20 April 2022

re: Residence
1837 Loop Road
Bunnlevel, North Carolina

I have inspected the construction at the above referenced address and note the following to the best of my knowledge:

Foundation
 New
 SHEET
 2

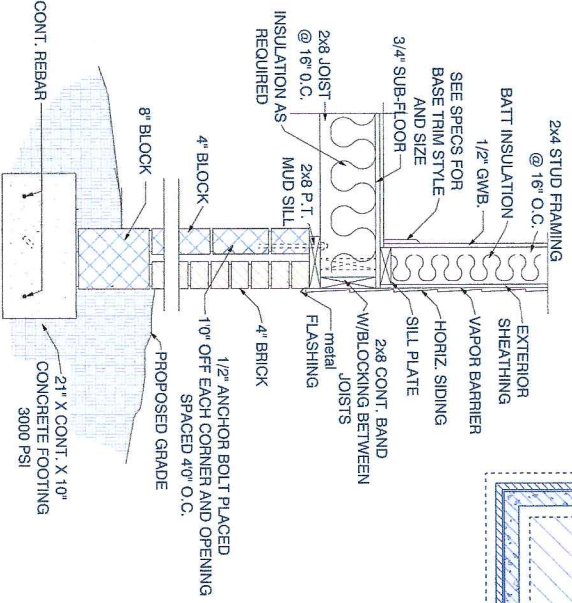
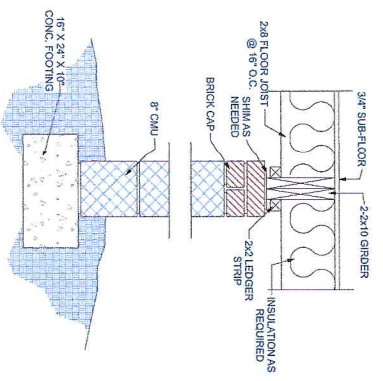
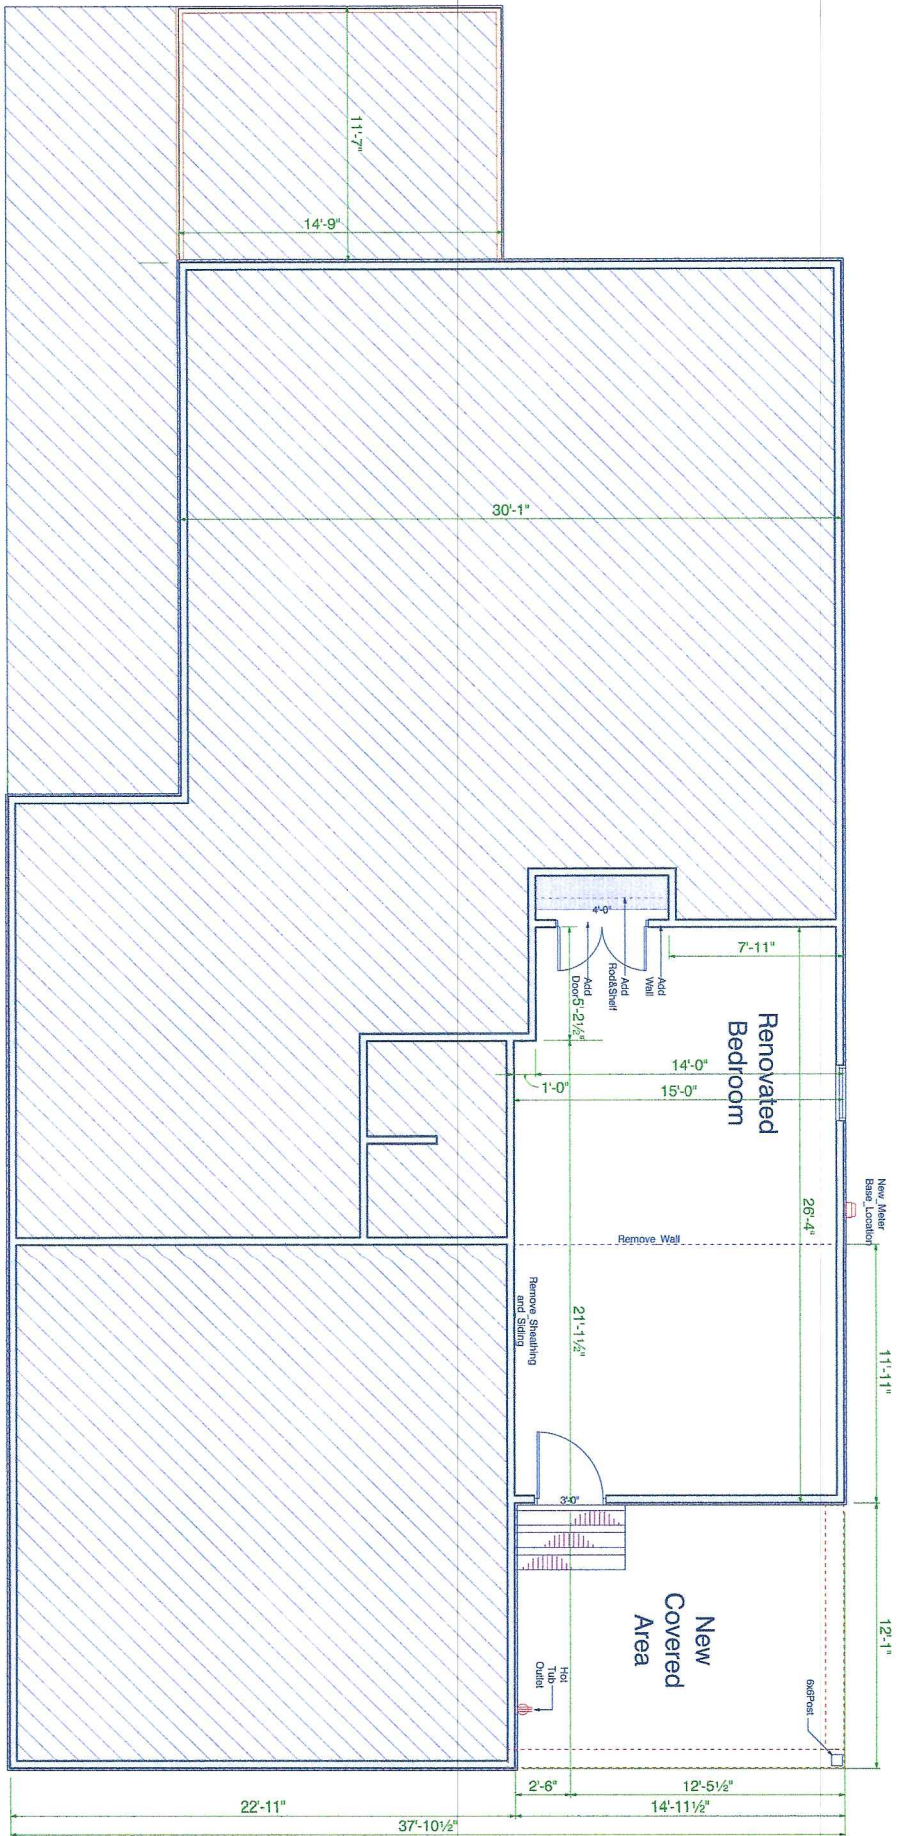
1. Based on the pictures provided by the contractor, the footings have the correct size and amount of re-bar and are doveled into the existing footing for the column and residence and are within the provisions of the 2018 NC Residential Building Code.
2. The 8" CMU that was installed for the heated space has a 1" corbel to the inside but still has 7" of bearing for the floor loads. There is not any roof loads on this foundation wall. I approve of the construction.
